12th August 2017

Replace two storey rear extension & erection of rear balcony & external staircase. 2 Elmer Court Middleton on Sea

Ref M/62/17/HH - Mr A Wood and Mr N Crowther

Drawing No. 1645/2010D

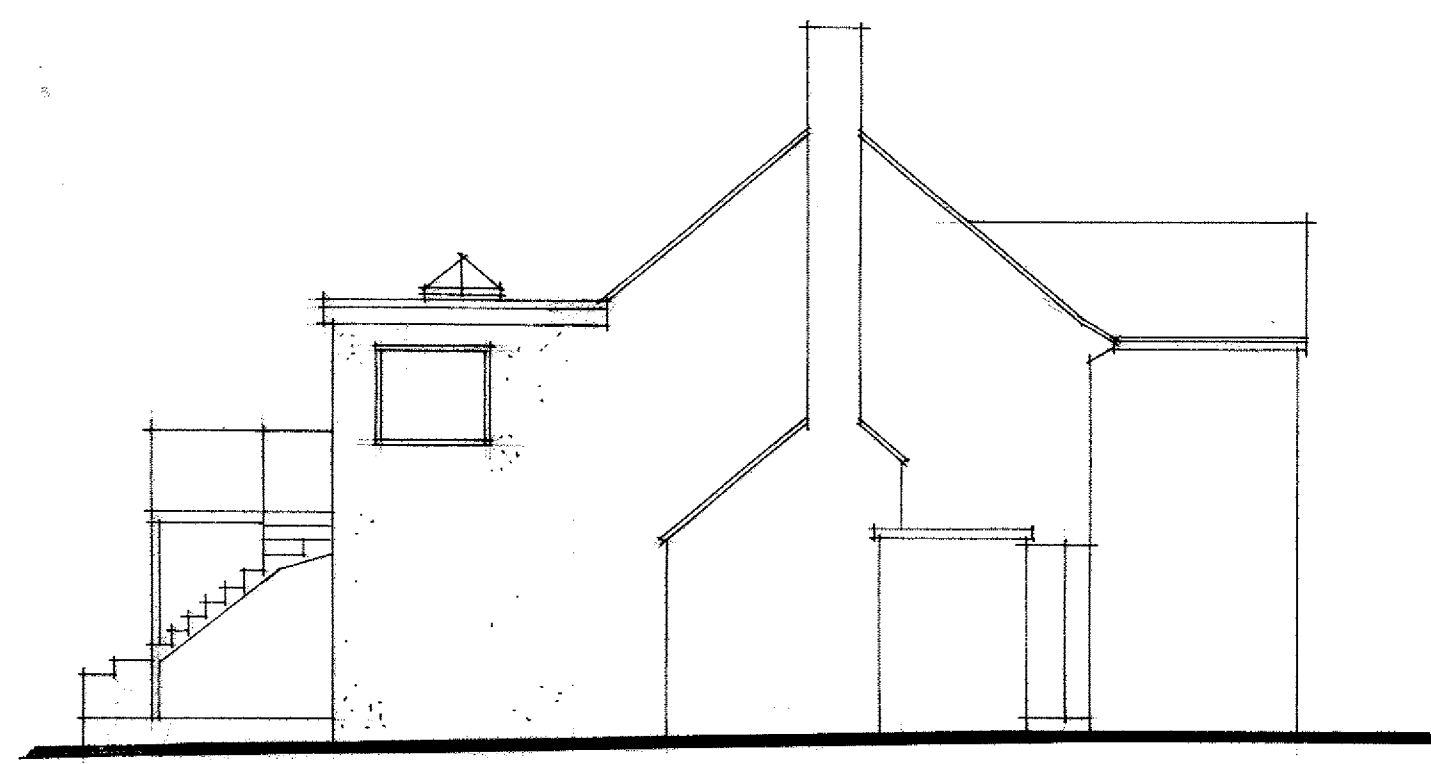
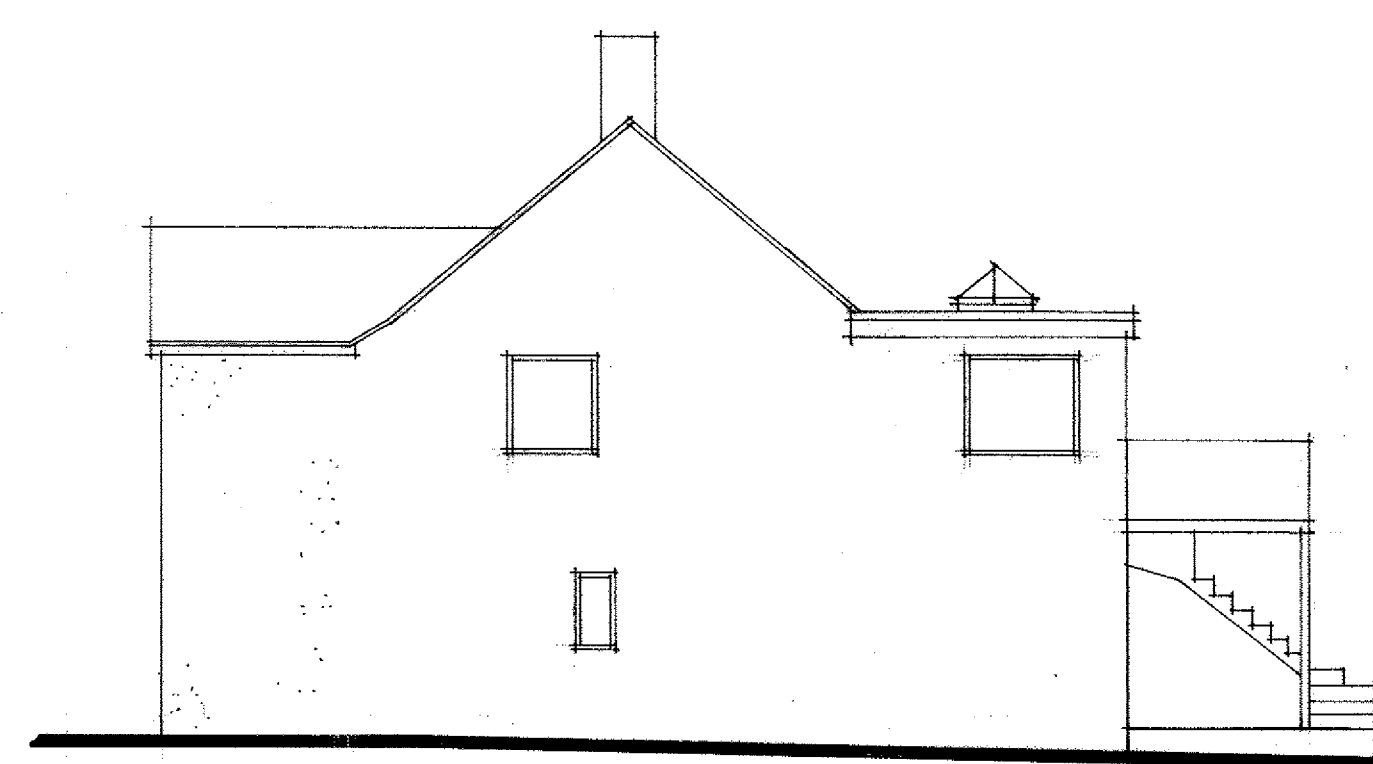
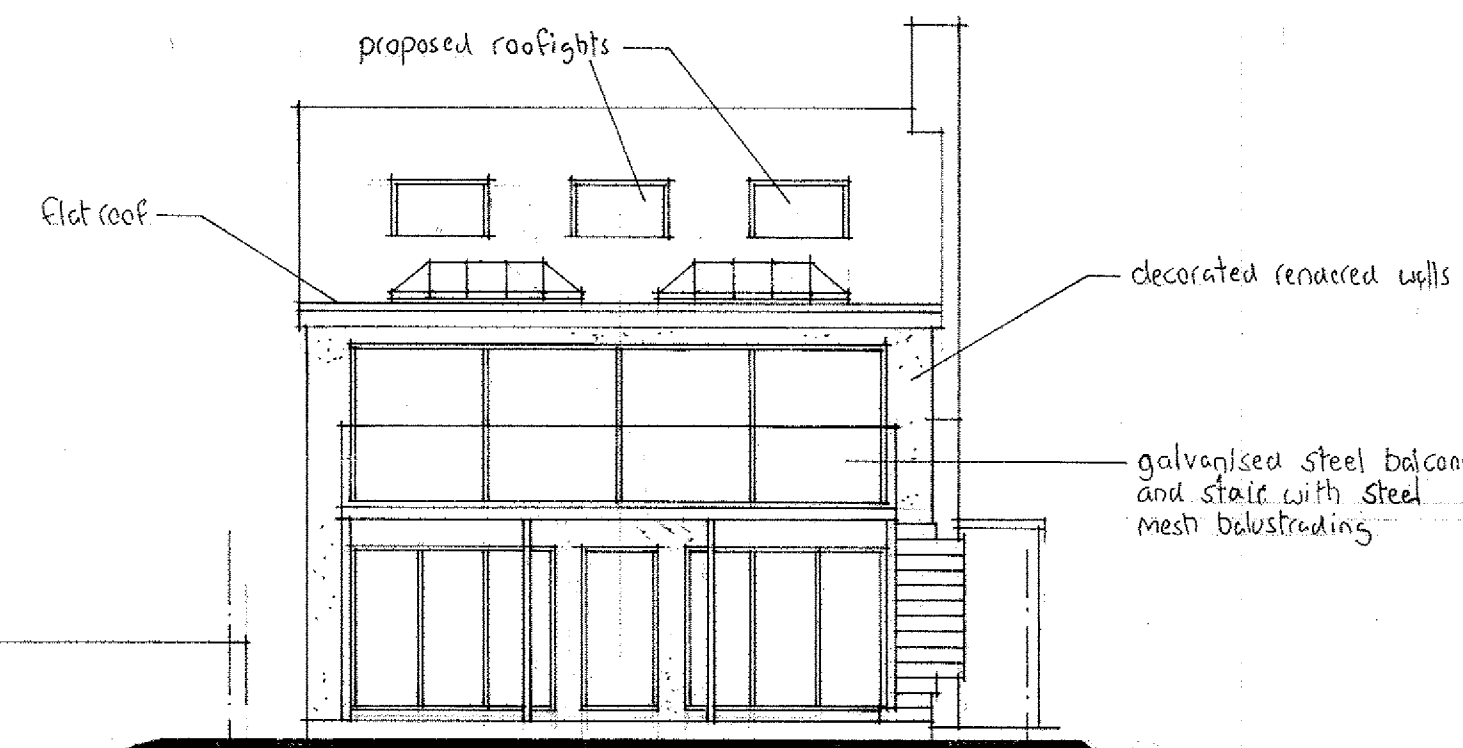
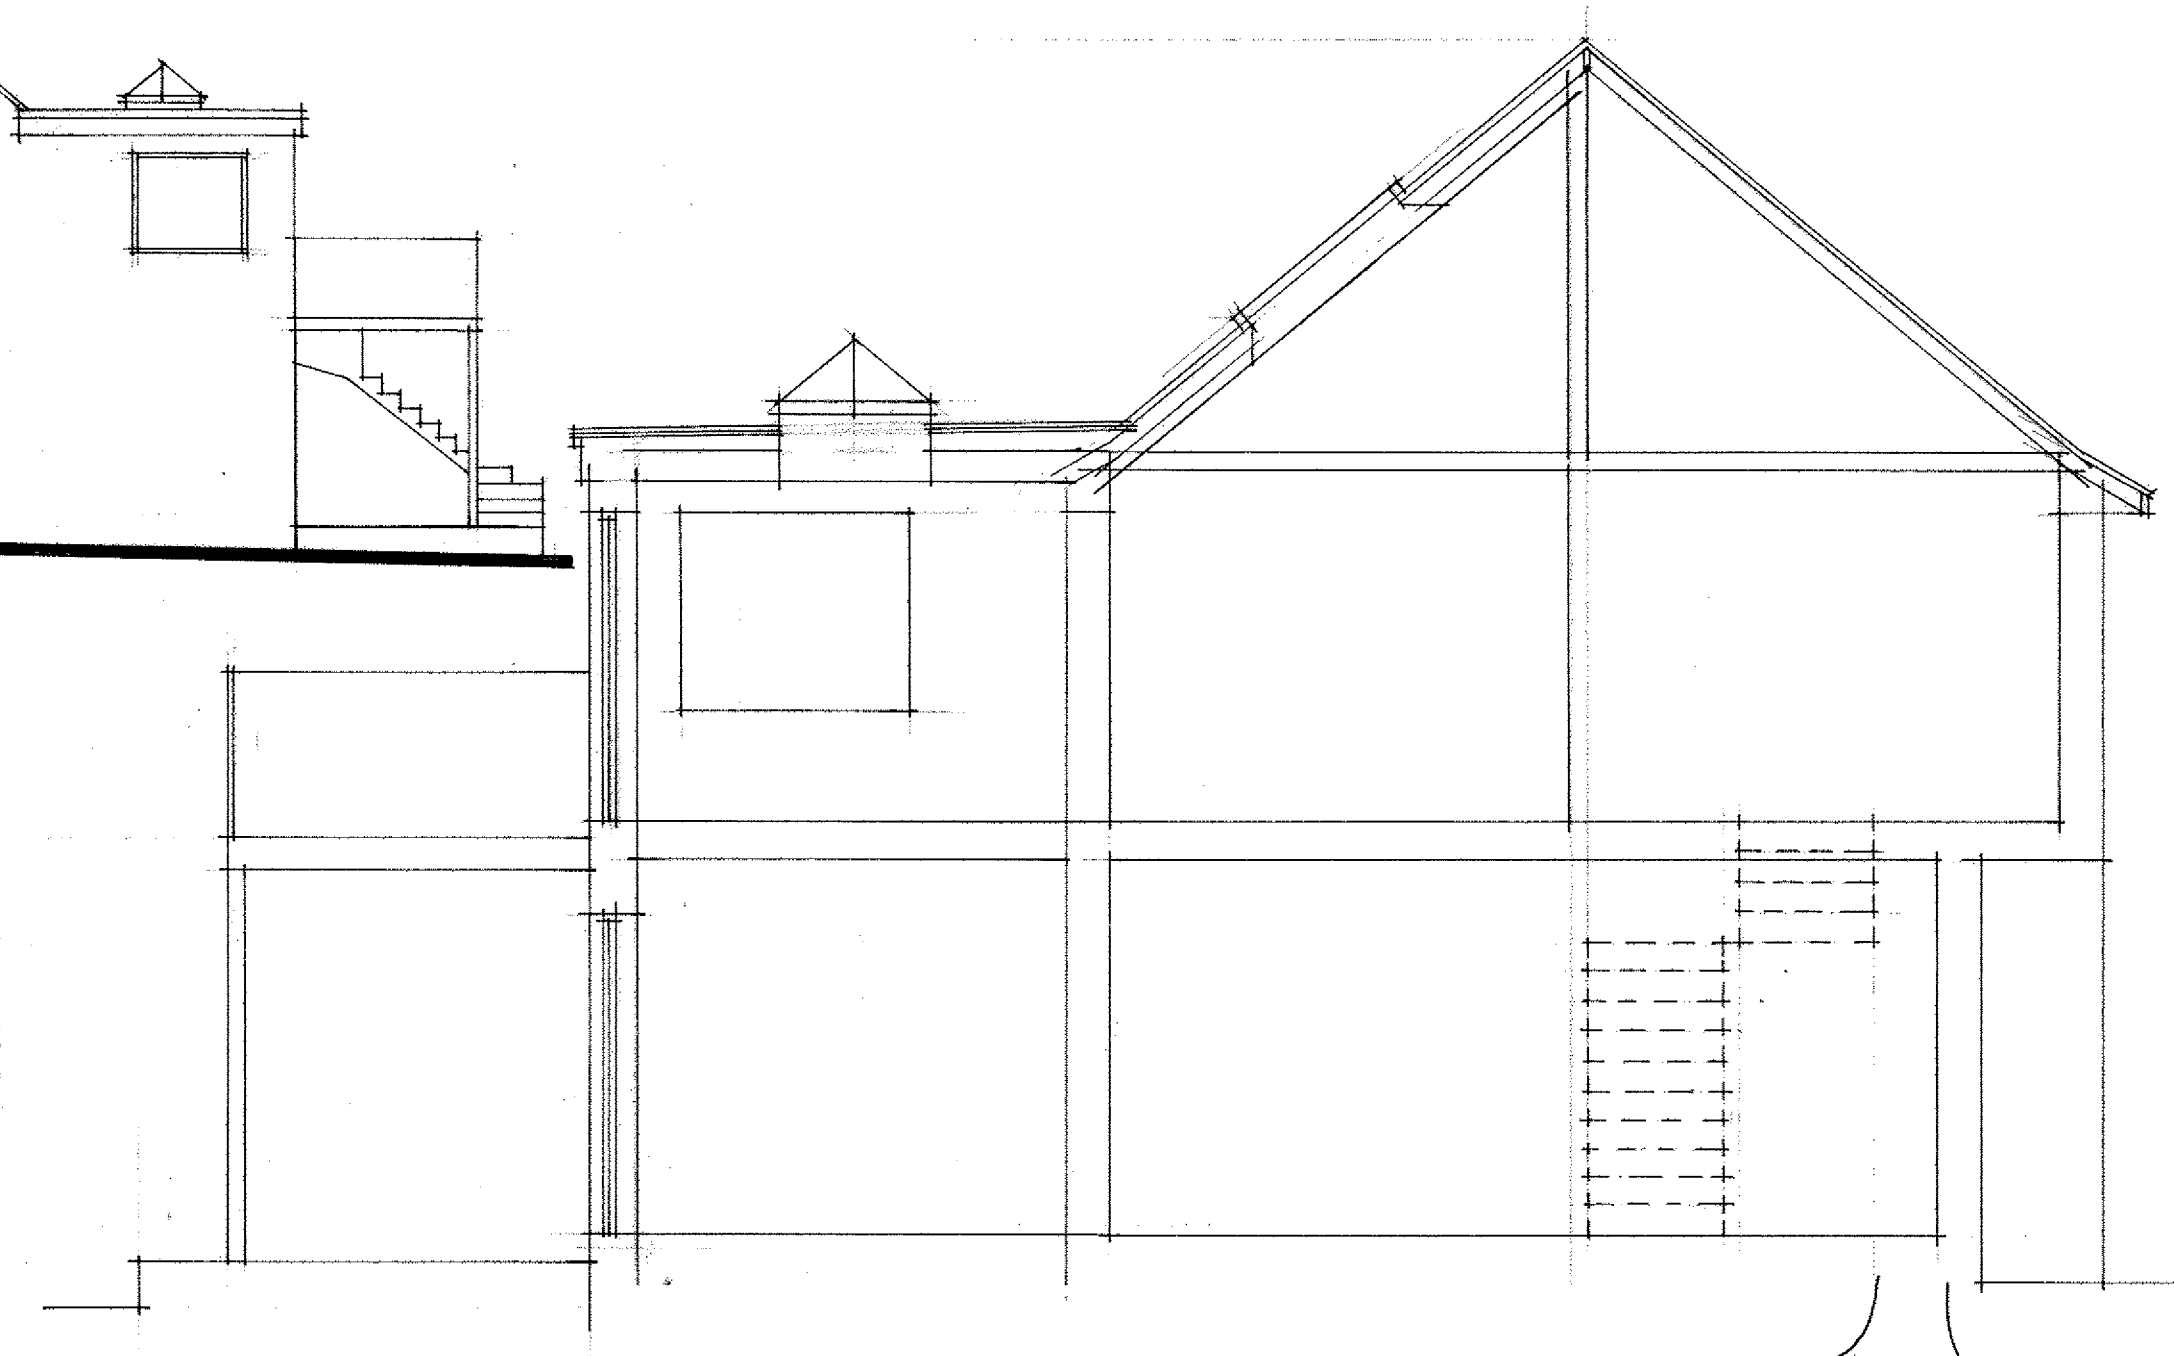
We assume the balcony will extend an additional 2.4 metres beyond the current extension, it would mean that the proposed development is 5.5m meters in total from the main house (2 Elmer Court without the current extension). The size of the extension including the proposed balcony is overbearing for the area it is in.

As the two buildings (1 Elmer Court and 2 Elmer Court) are very close together, the extension with the balcony would effectively mean we would have a long high wall of about 4.5 metres in height (over two levels) at a length of about 5.5m, ie stretching along a third of our garden. This will impinge significantly on our privacy and the ability to enjoy our garden. We tried to demonstrate this effect in an attached drawing (Appendix 1 - Proposed new Extension with balcony).

The erection of the balcony at the proposed height would mean that our whole garden can be overlooked from 2 Elmer Court despite installing privacy glass on the Western side. This will significantly impinge on our privacy.
